Re: BP#2016-01765 667 Congress Street - Plan review

I am handling the plan review for Joe's Variety. Given the slight change in the floor plan from what was originally proposed, can you provide the following:

SHEET TITLE:
BASEMENT FLOOR PLAN

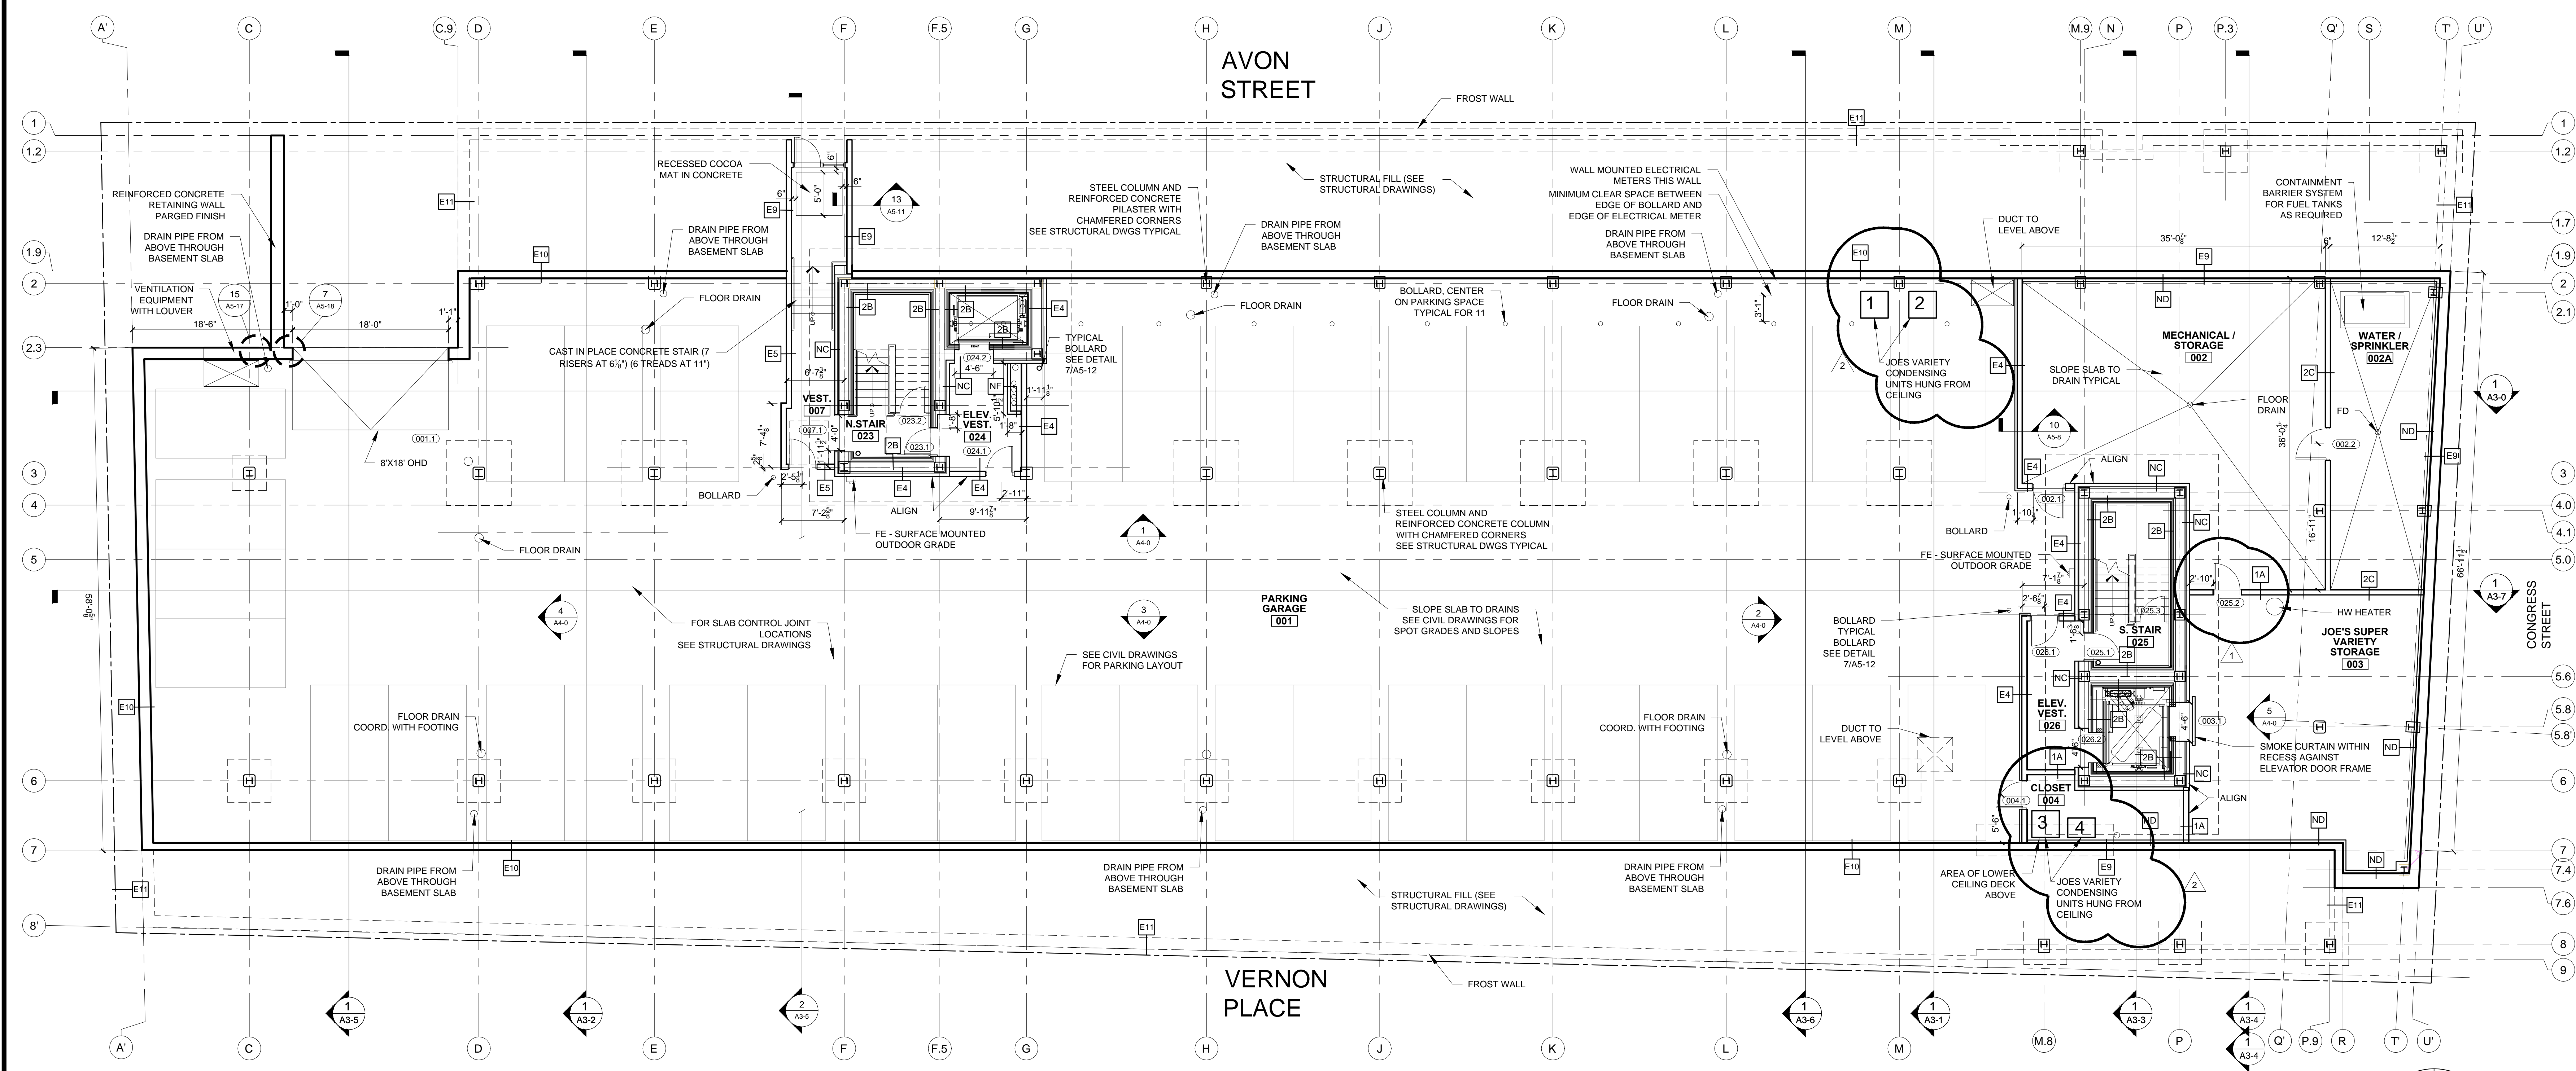
1. Occupant load for the revised floor plan.
2. Provide lower level floor plan as well as the first floor plan provided.
3. Per Figure 404.2.4.1 Maneuvering Clearances at Manual Swinging Doors and Gates, clarify if the maneuvering clearances and push/pull approaches are adequate
4. Label mop sink in the kitchen floor plan.
5. Provide the elevations at the top and bottom of ramp with verification that the ramp meets the requirements of Section 1010.2 Slope.

- 1.) The occupant load of Joe's Super Variety is 70 unchanged from before
- 2.) Please see the Basement Plan A1-0
- 3.) These have not changed per your review during the Base Building Permit, which we addressed during that review, please see item # 3 in the attached memo dated 5/13/16.
- 4.) The mop sink is shown as item 'N' in the women's bathroom, we reviewed this location with Danielle Davis and she said it was fine there (please see the email chain from her and I at the bottom of this email)
- 5.) Please see the attached ramp added notations on the plan A1-50, the ramp elevation change is 3" and it is 36" long so a 1:12 slope per ADA.
